Rezoning Transportation Analysis

Petition Number: 2024-022

General Location Identifier: 03703102, 03703113

Date	Description
3-27-24	First Review (IW)
04-24-24	Second Review (KC)
05-22-24	Third Review (IW)

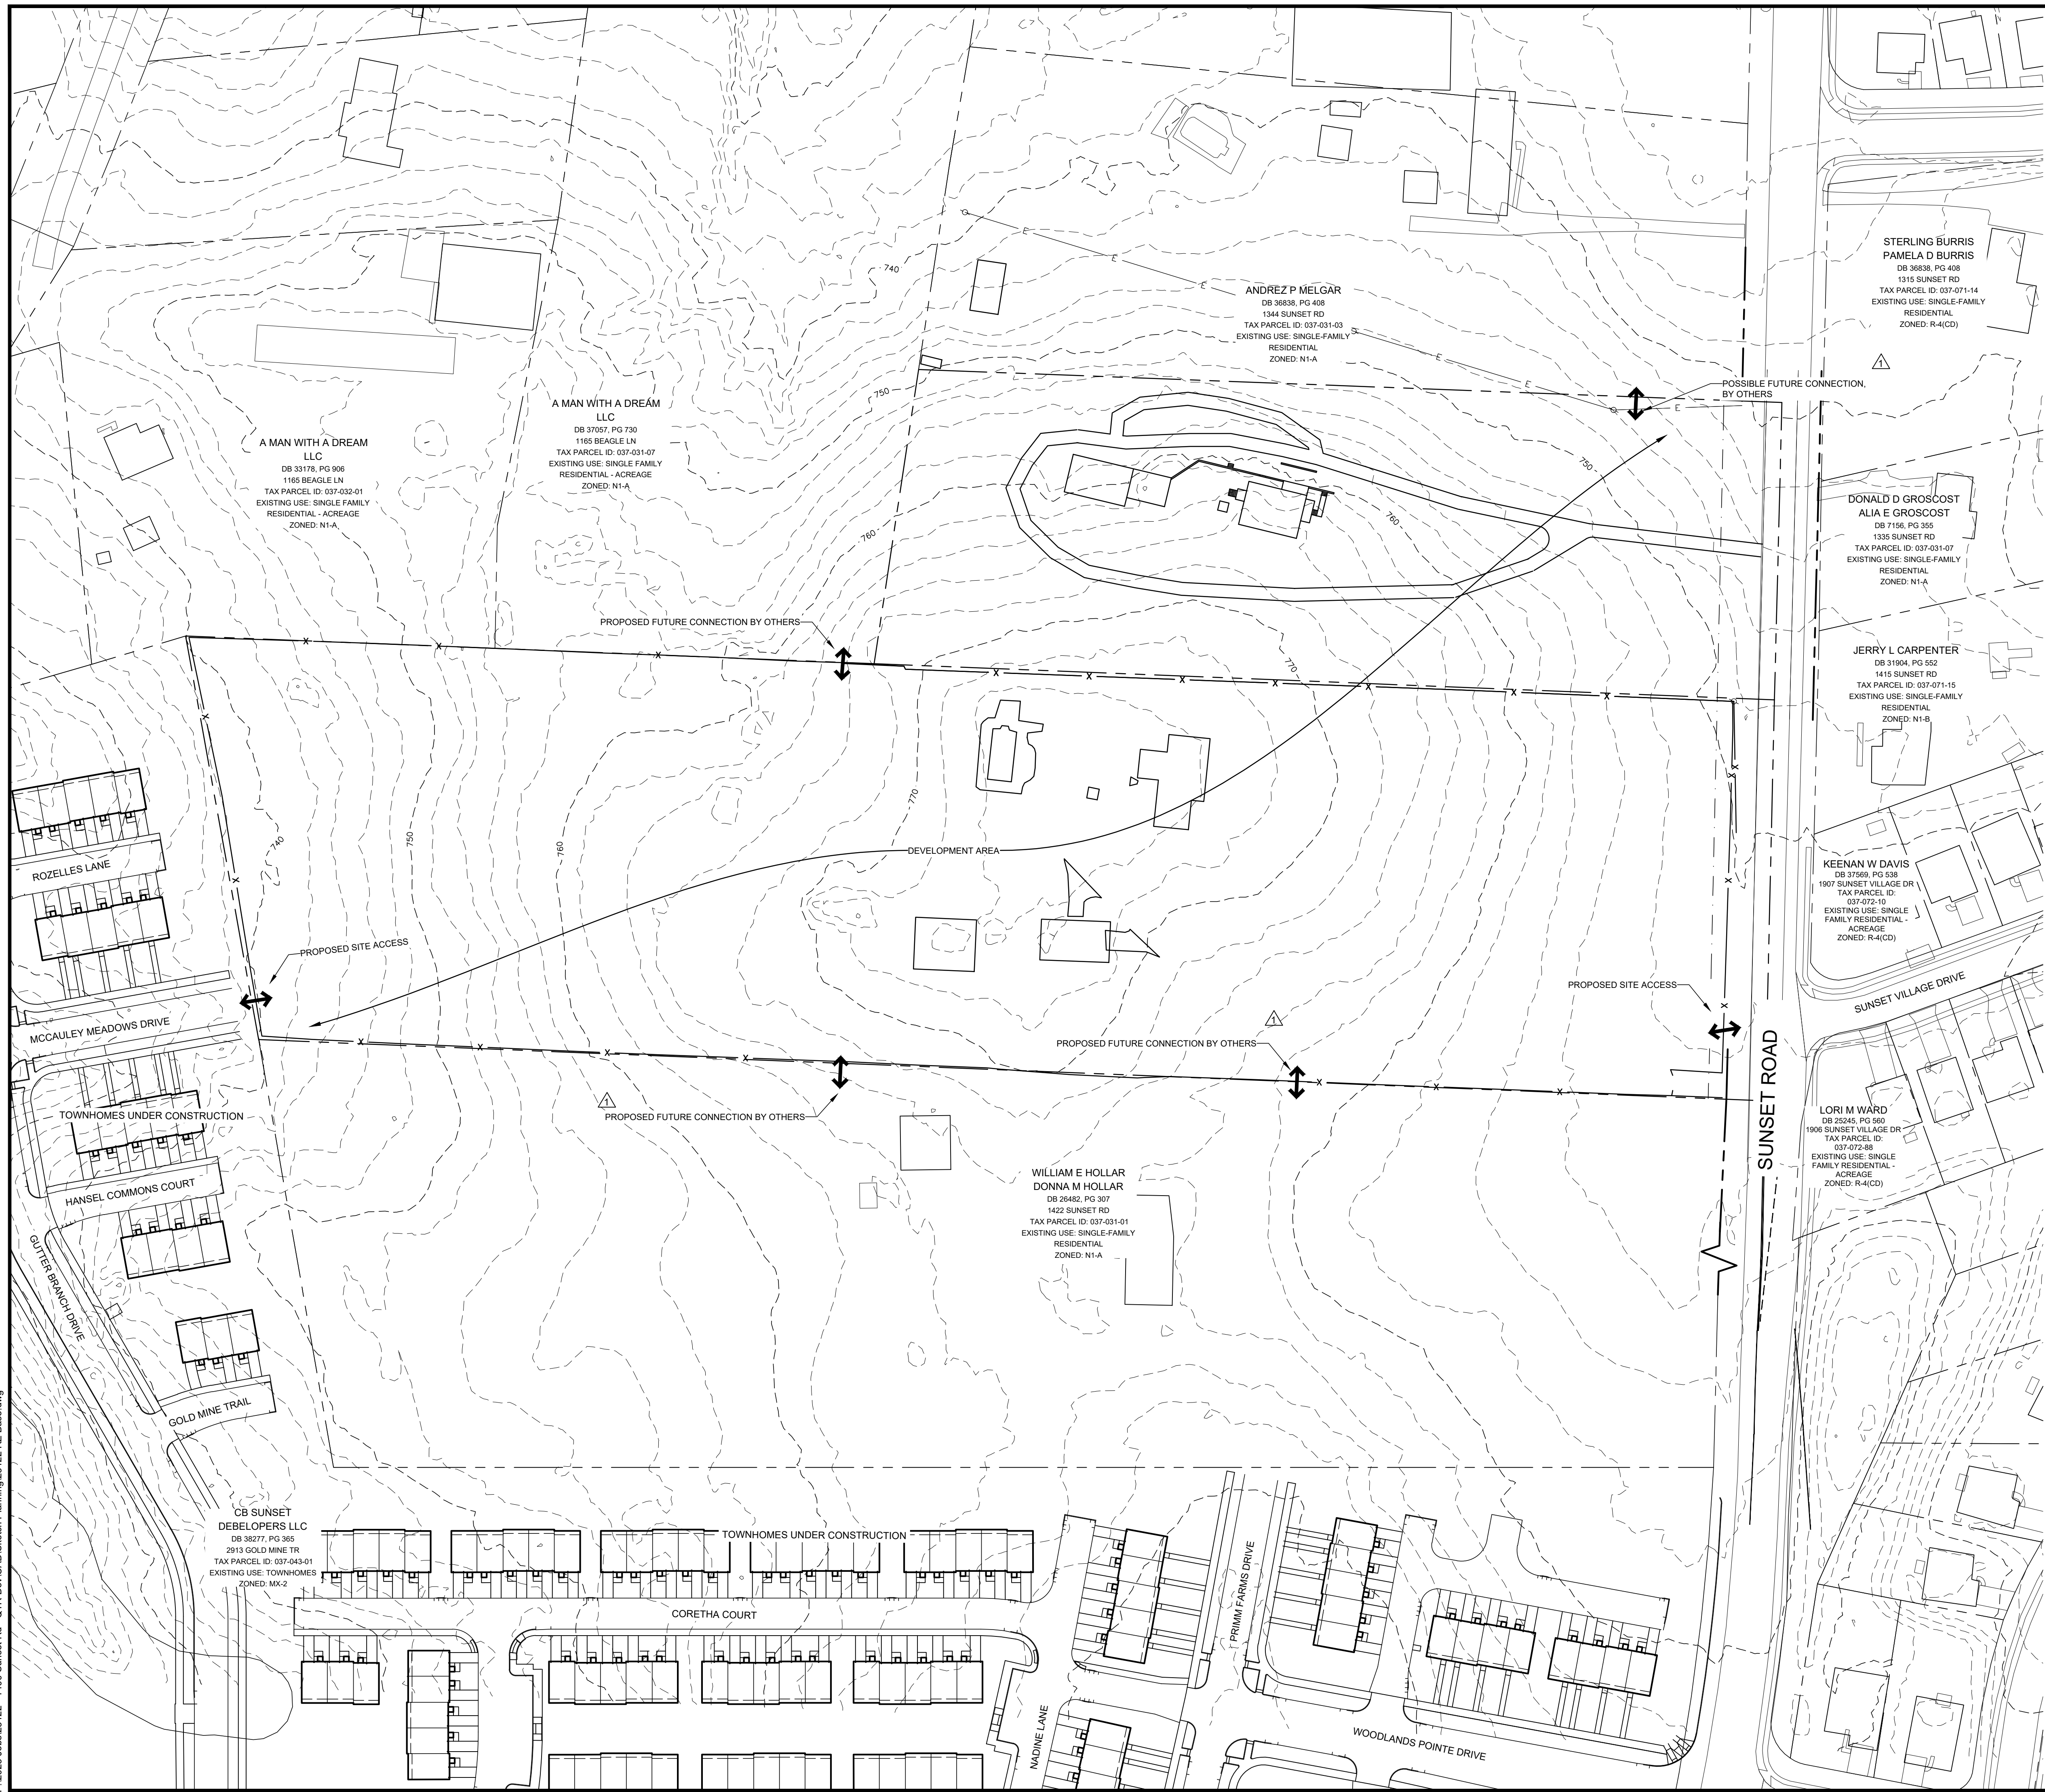
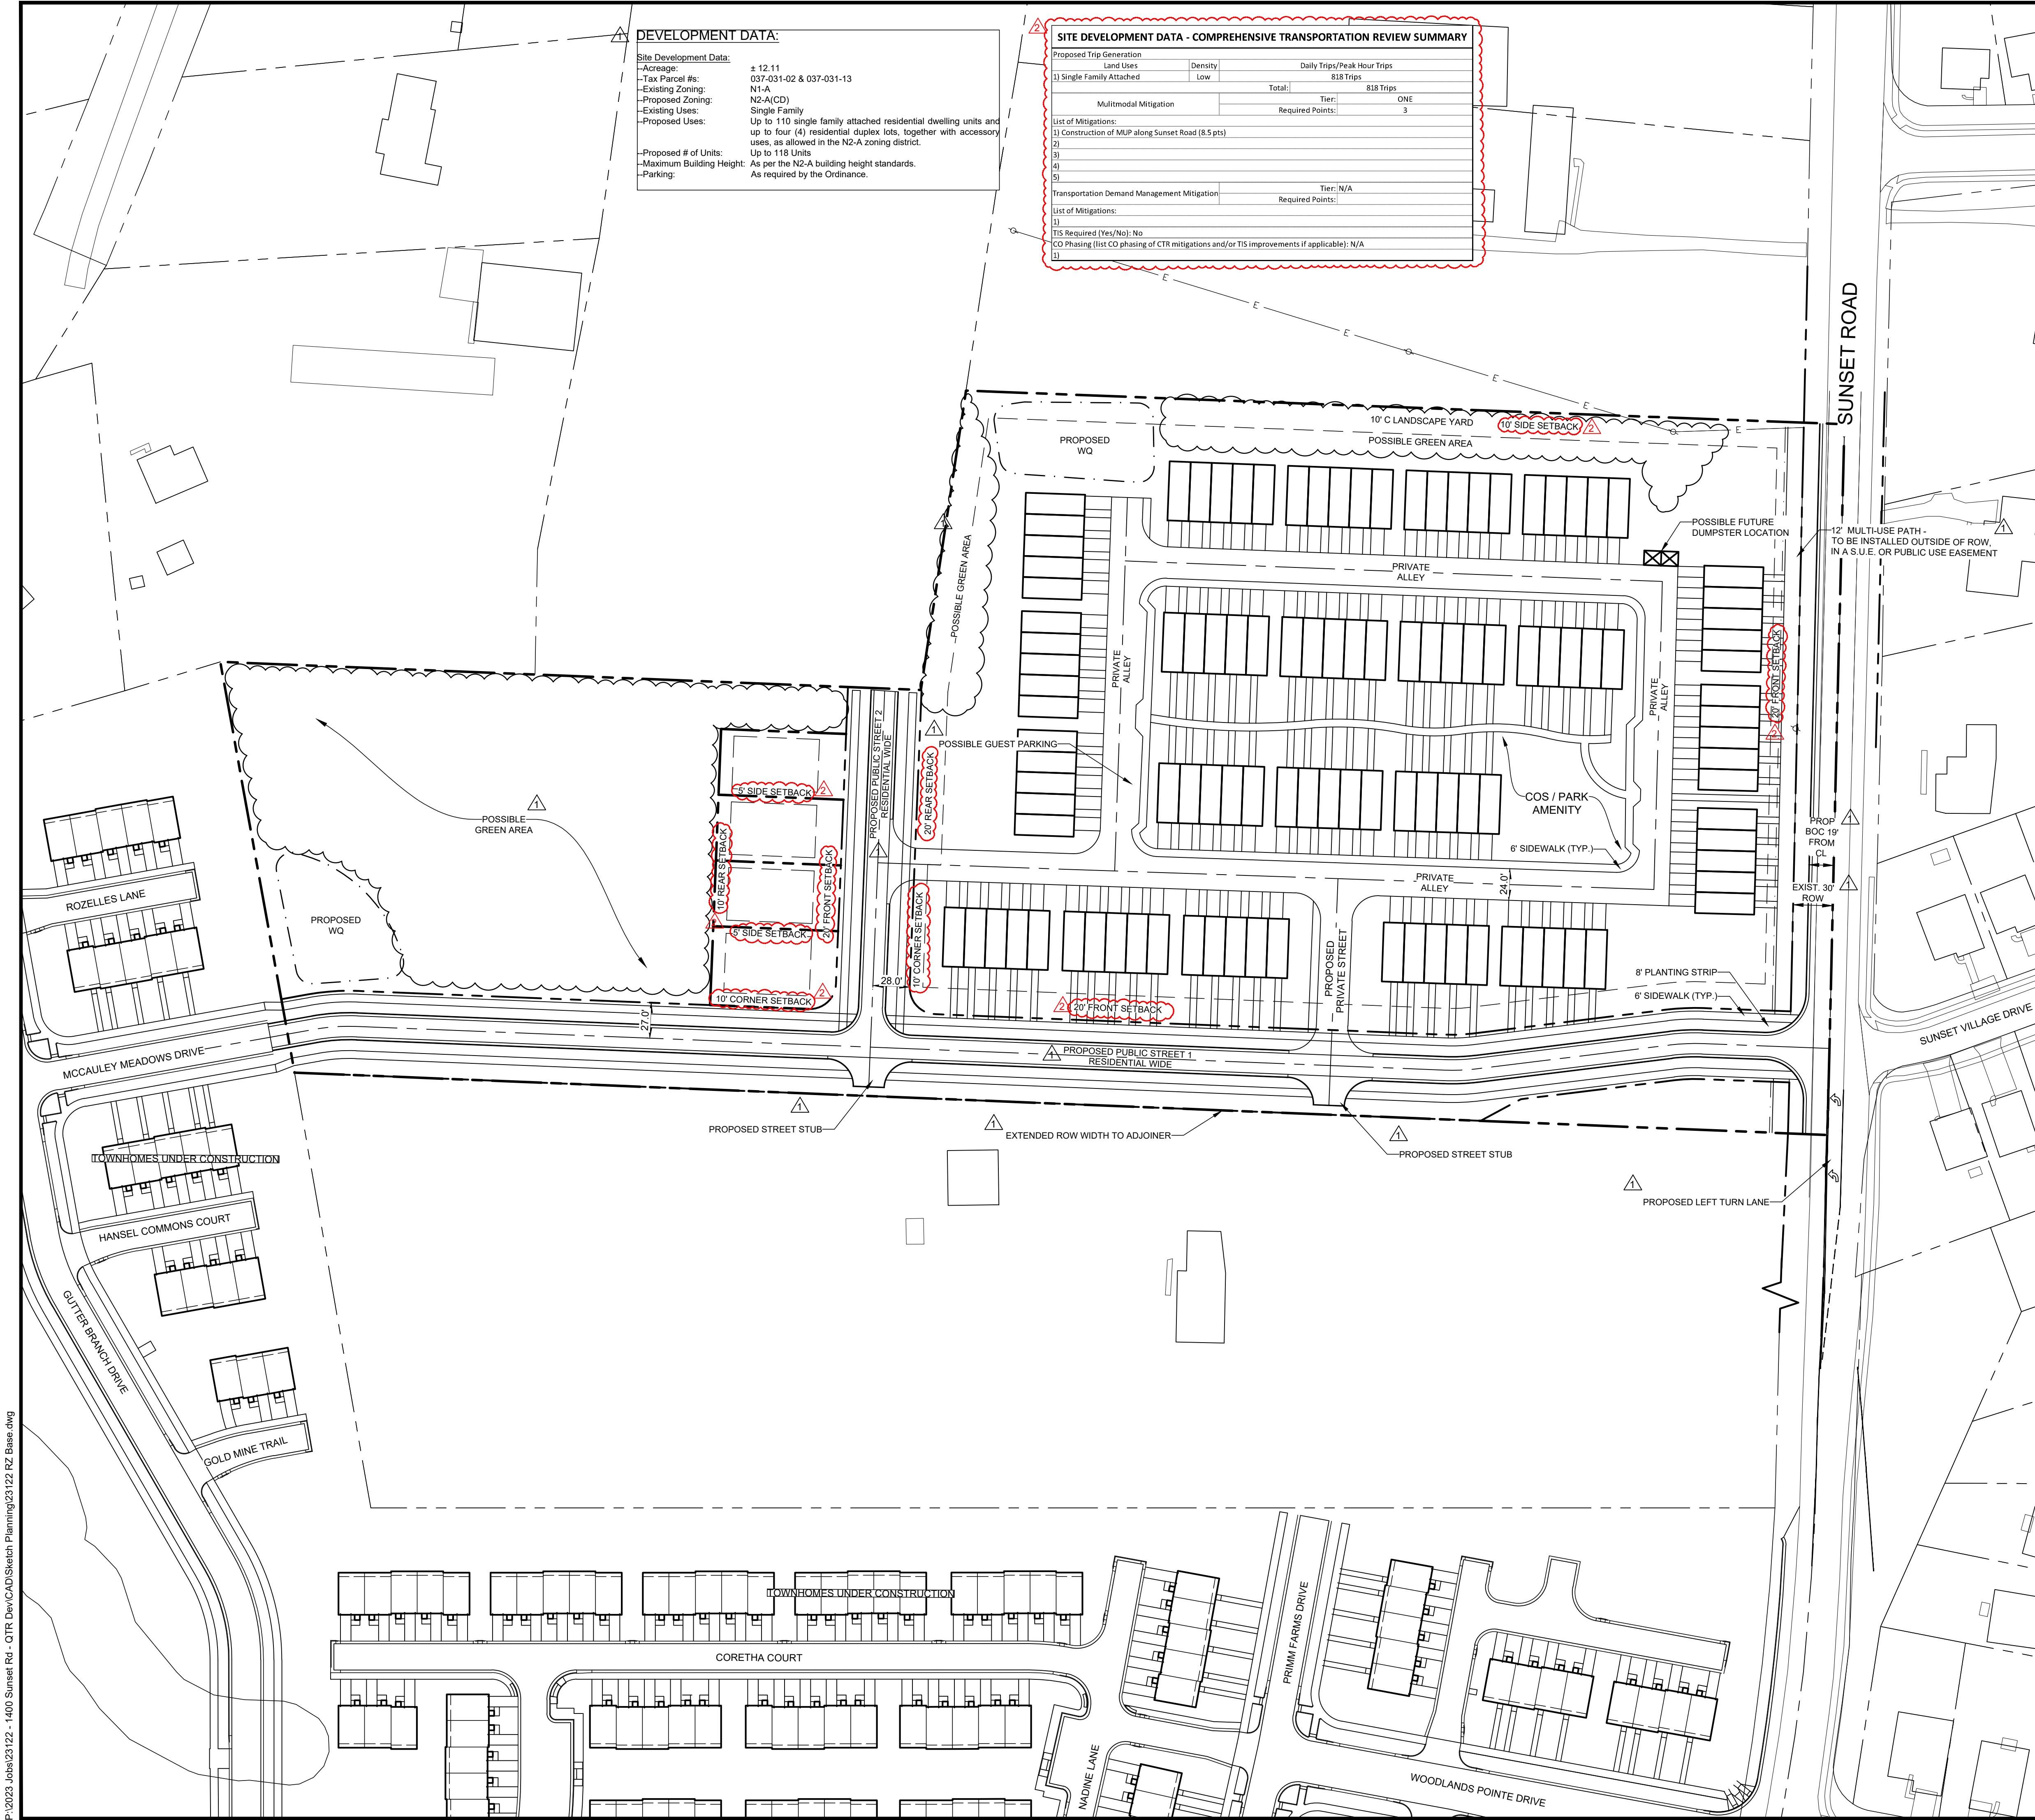
04-24-24 Outstanding Comment: ~~Ramps internal to the site are not applicable for CTR requirements. Additionally, points for SUP are provided based on total length (.5 points per 25 linear feet constructed).~~

Please provide total length of proposed SUP to verify the total number of points earned. Reach out to Ty Parham at ty.parham@charlottenc.gov for additional requirements.

- Outstanding Comment 03-27-24:** Revise site plan and conditional note(s) to commit to creating cross-access with the Northern Parcel fronting Sunset Road per Article 31.2 in the UDO.
Outstanding Clarifying Comment: Show proposed cross access with the Northern Parcel at some location along the property line. Per UDO 33.6 the cross-access connection shall have a minimum 20 foot wide two-way paved connection.
